From: Michael Eastham
Sent: 21 March 2018 12:26
To: Planning.Responses
Subject: FW: 4485 - Courtwick Littlehampton - variation of conditions 4 & 24 - Ref LU/408/17/PL

Would you like "Drawing Number 4485/314 Rev. E – North Eastern Footpath Link Details Plan" to be listed as an additional plan in the varied Condition 4, which was imposed on the outline planning permission (LU/355/10/)?

DMA Strider Max 4 Mobility Scooter	1.440m
Overall Length	0.650m
Overall Width	1.225m
Overall Body Height	0.165m
Min Body Ground Clearance	0.650m
Track Width	2.00s
Lock to lock time	1.650m
Wall to Wall Turning Radius

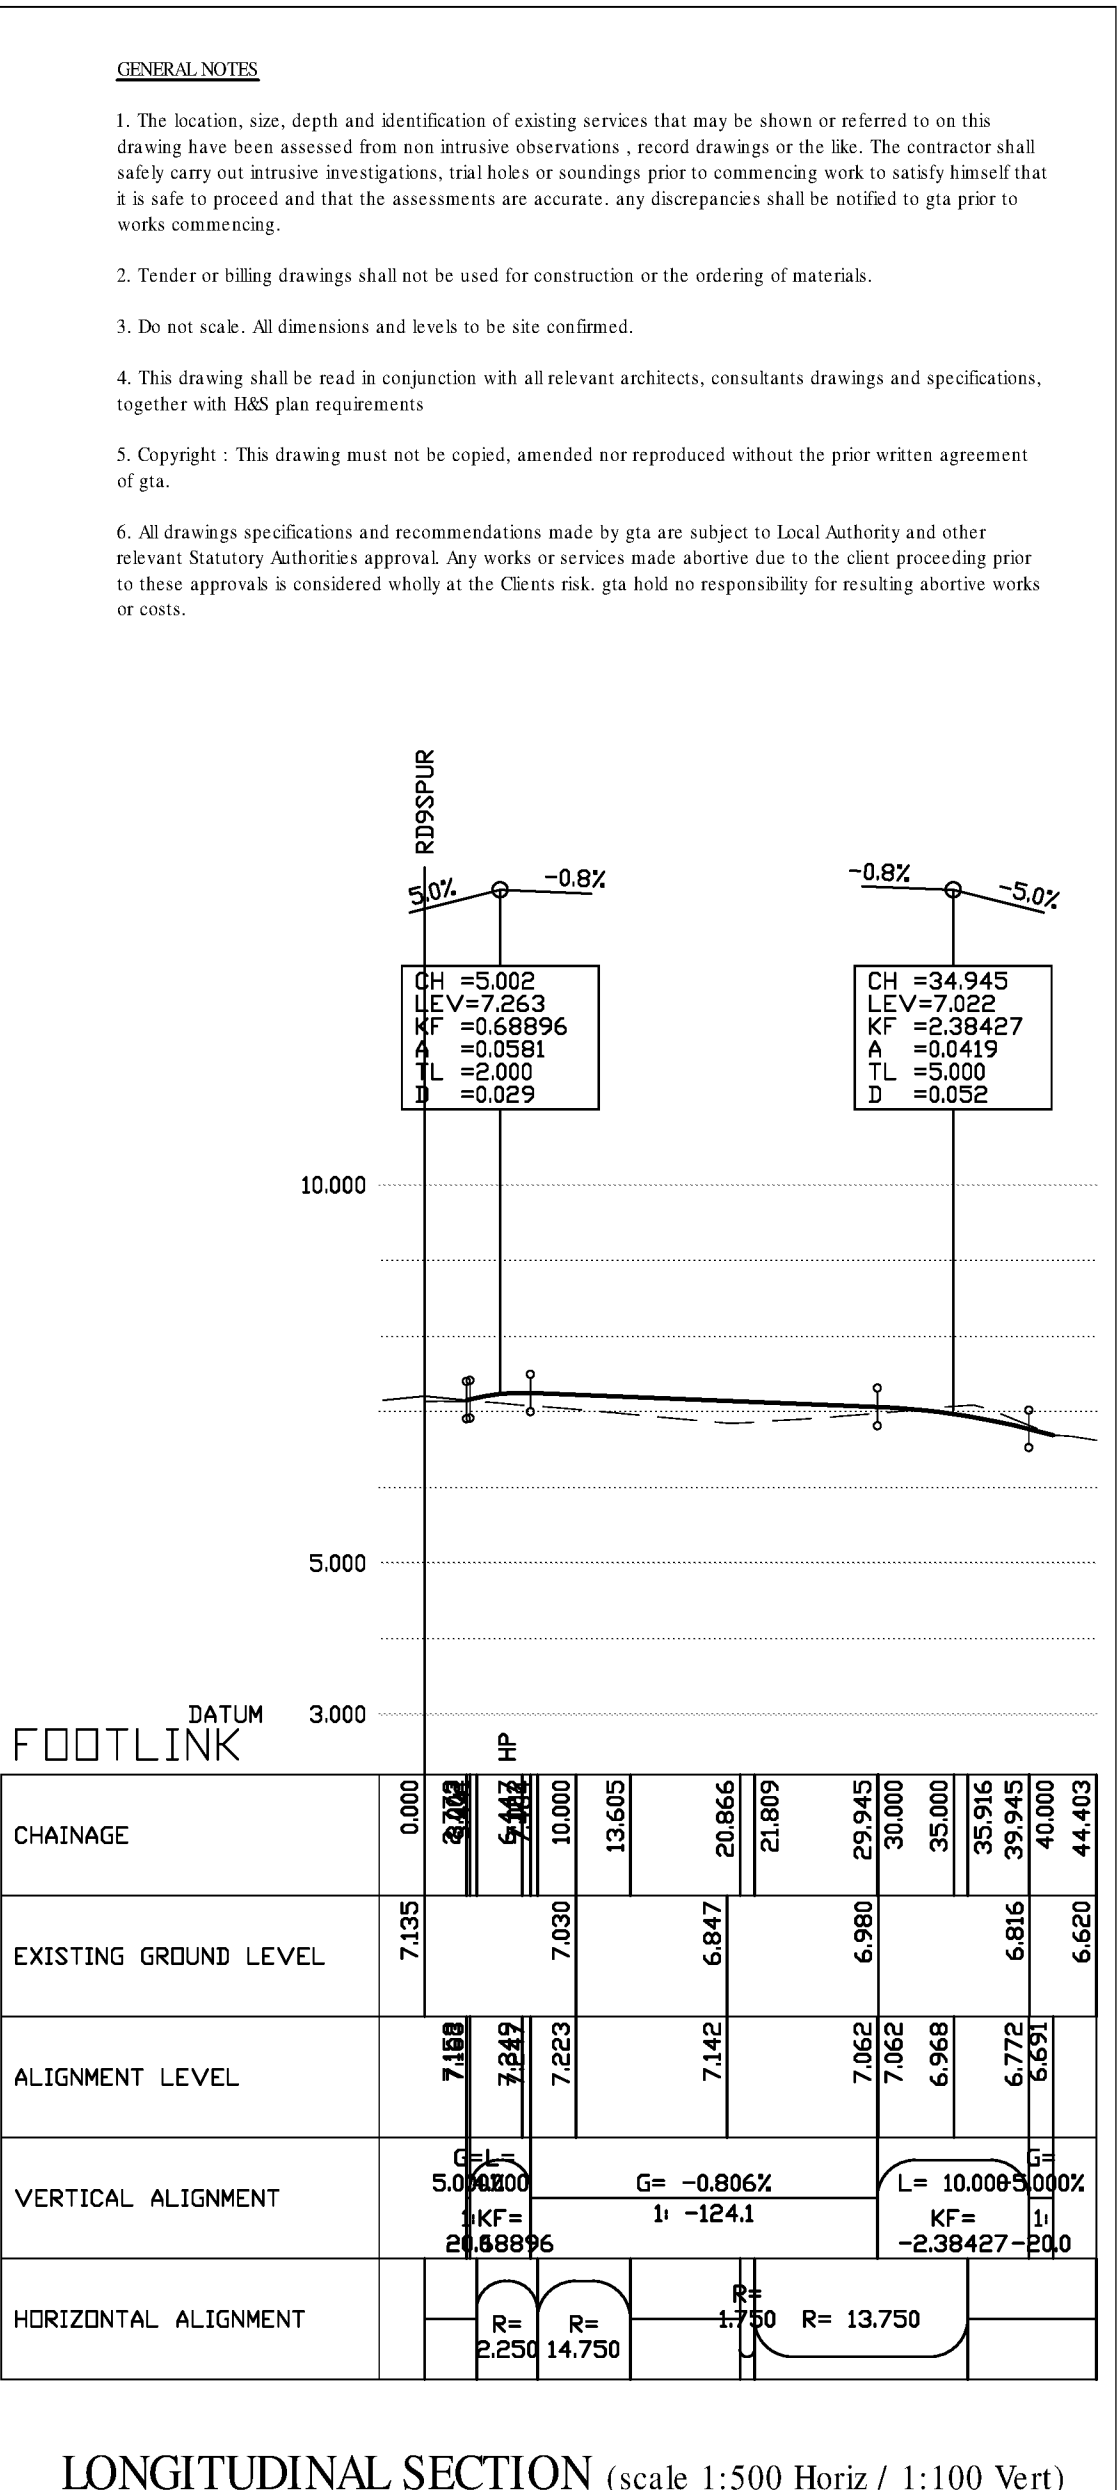
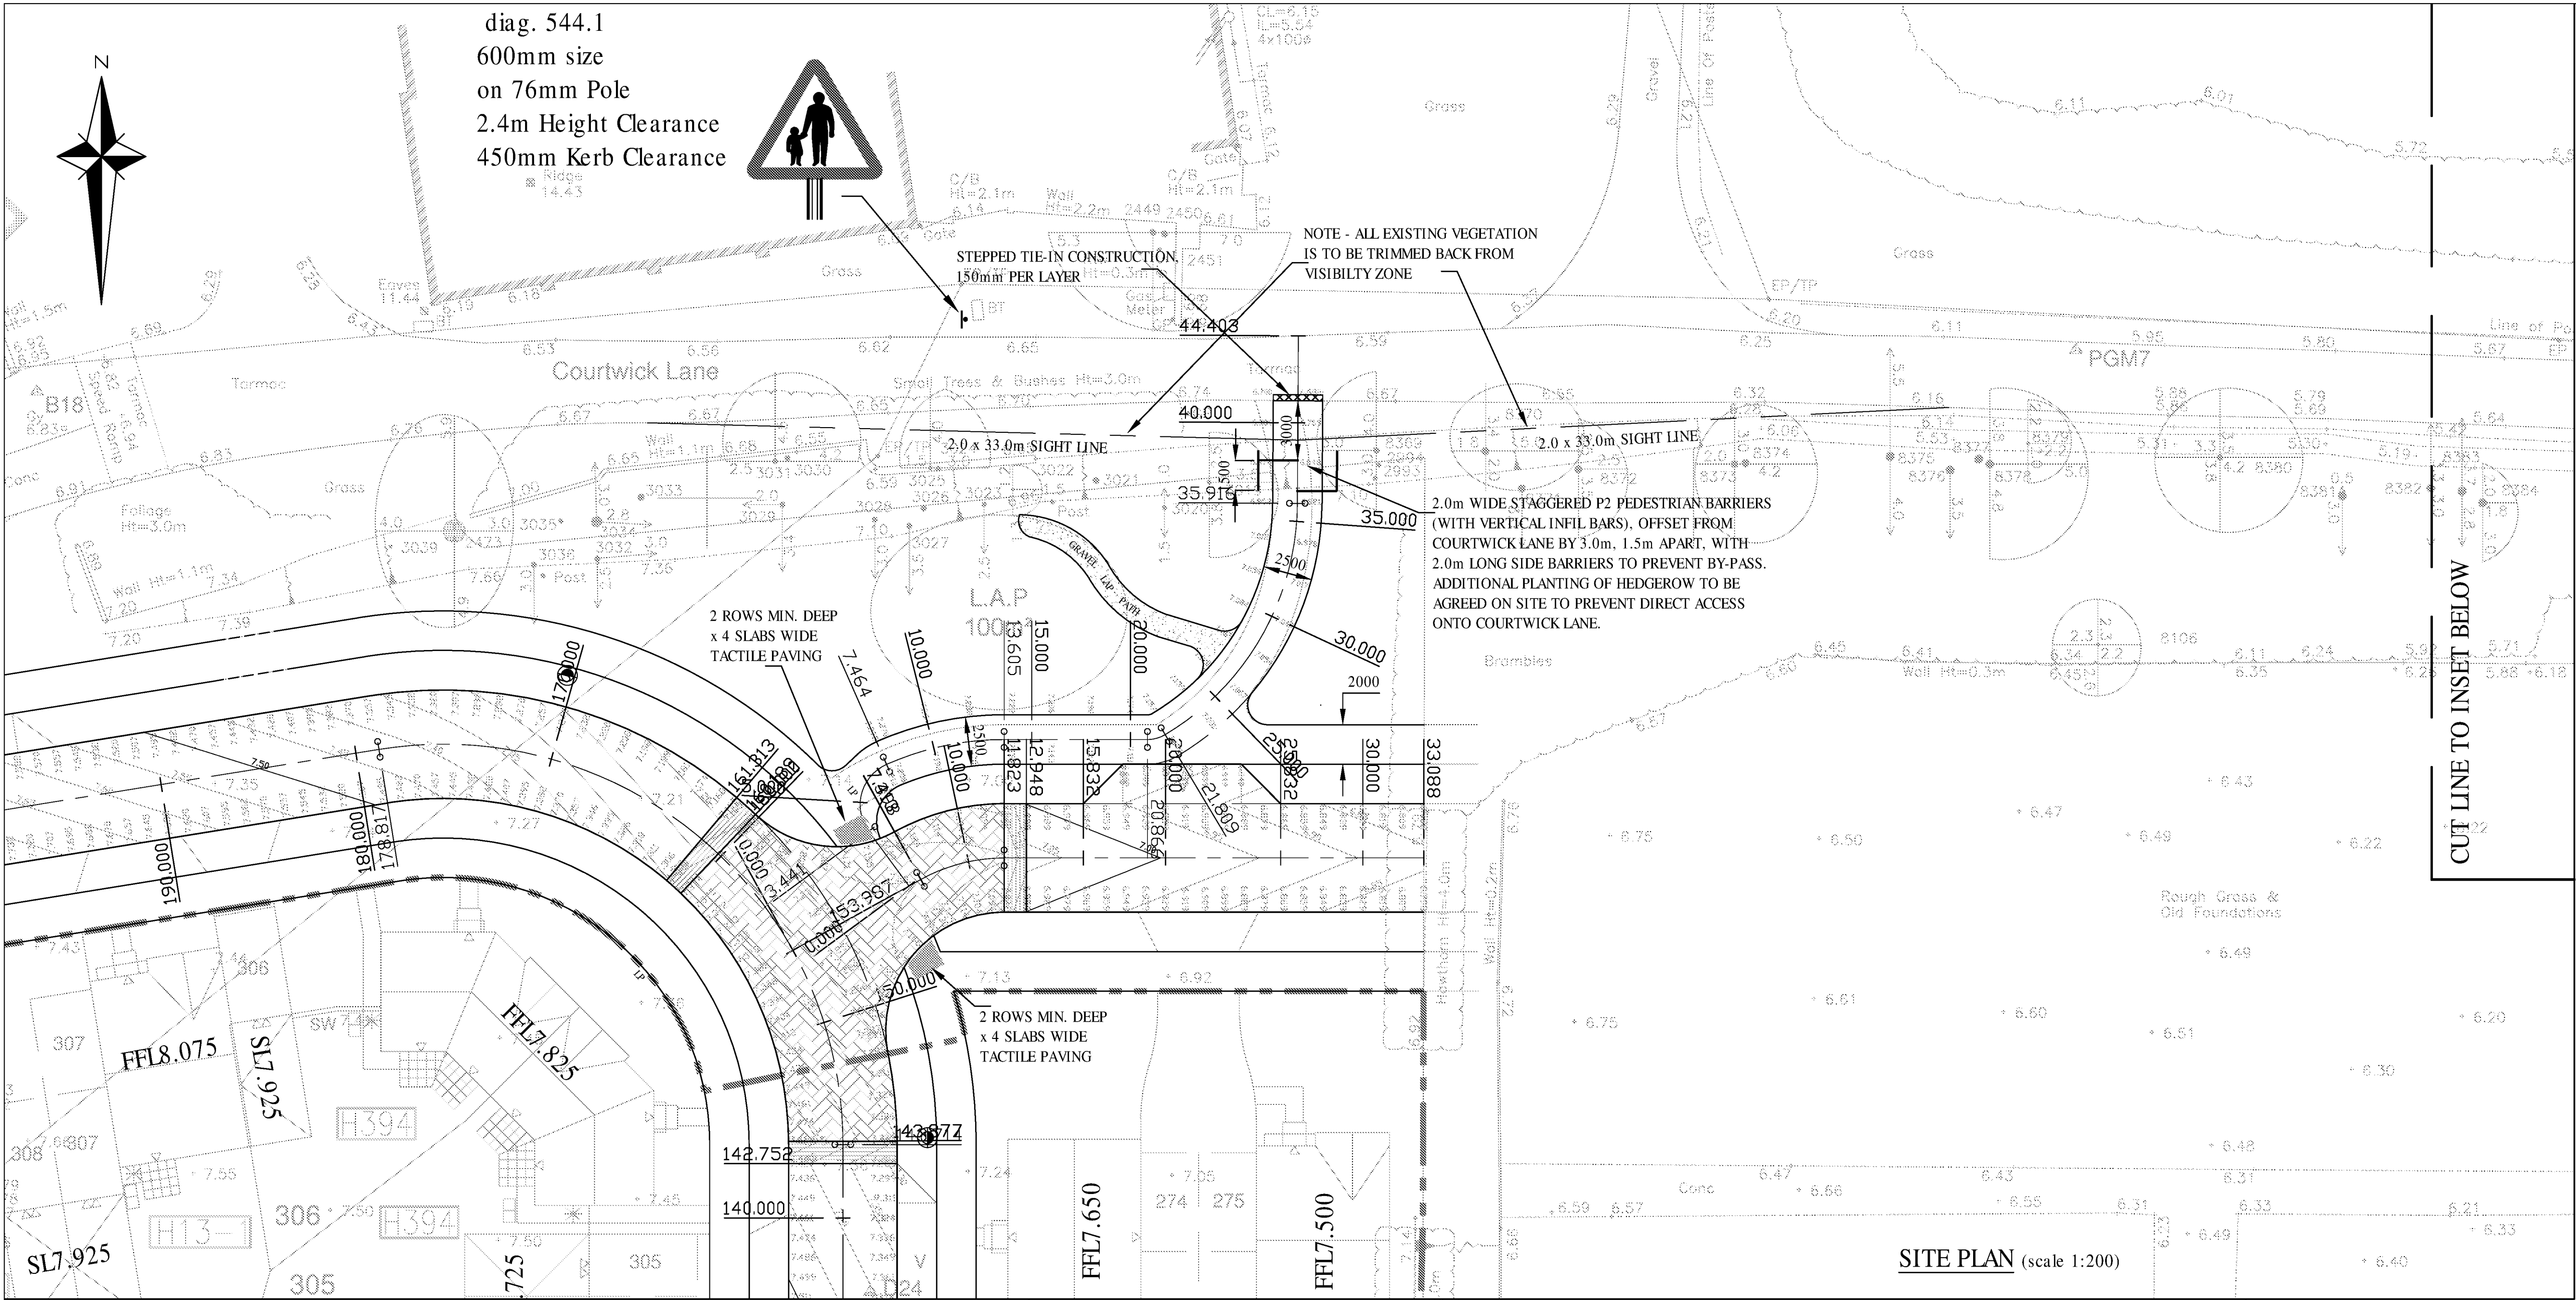
As far as I can see, the arrangements proposed by Bellway is still one that looks to be suited for cyclists. Furthermore, the stagger of the barriers might be the wrong-way-around and the use of hoops with 1200mm clearance underneath would permit a young child to walk or run underneath. They also might need to be a bit closer to the road (albeit not within the sight line splays). Finally, the gap in the middle would permit cyclists to traverse fairly quickly so should – I believe – be narrowed. However, the applicant would still have to demonstrate that those with pushchairs and mobility scooters can get through them. Sustrans guidance might assist here (*SEE LINK BELOW). Finally, there must be barriers (e.g. fence) either side to prevent the gates from being by-passed. In any event, appropriate design guidance will have to inform the final solution. However, it is still unclear what design guidance they have used to inform the proposal as the extract that you/they have provided is not one I have seen before. This should still be clarified, please.

For information, I have attached an example photo showing barriers that would prevent children getting underneath (although the spacing between the stagger still looks too large).

I don't think they are far-off now – we just need to see a bit more detail and confirmation of what guidance has informed what's shown.

Further to Tim's additional comments, please find attached the updated Footpath Layout with adjusted barriers and additional notes regarding supplemental planting (tba on site).

The 'Sustrans' guidance does not provide a specification for non-cyclist barriers and the former was taken from the 'paths for all' guidance with a recommended spacing of 3m – though from 'Sustrans', this is acceptable for cycle use. I have reduced the spacing to 1.5m and have also provided a tracking diagram for a mobility scooter which confirms that this spacing should be acceptable.
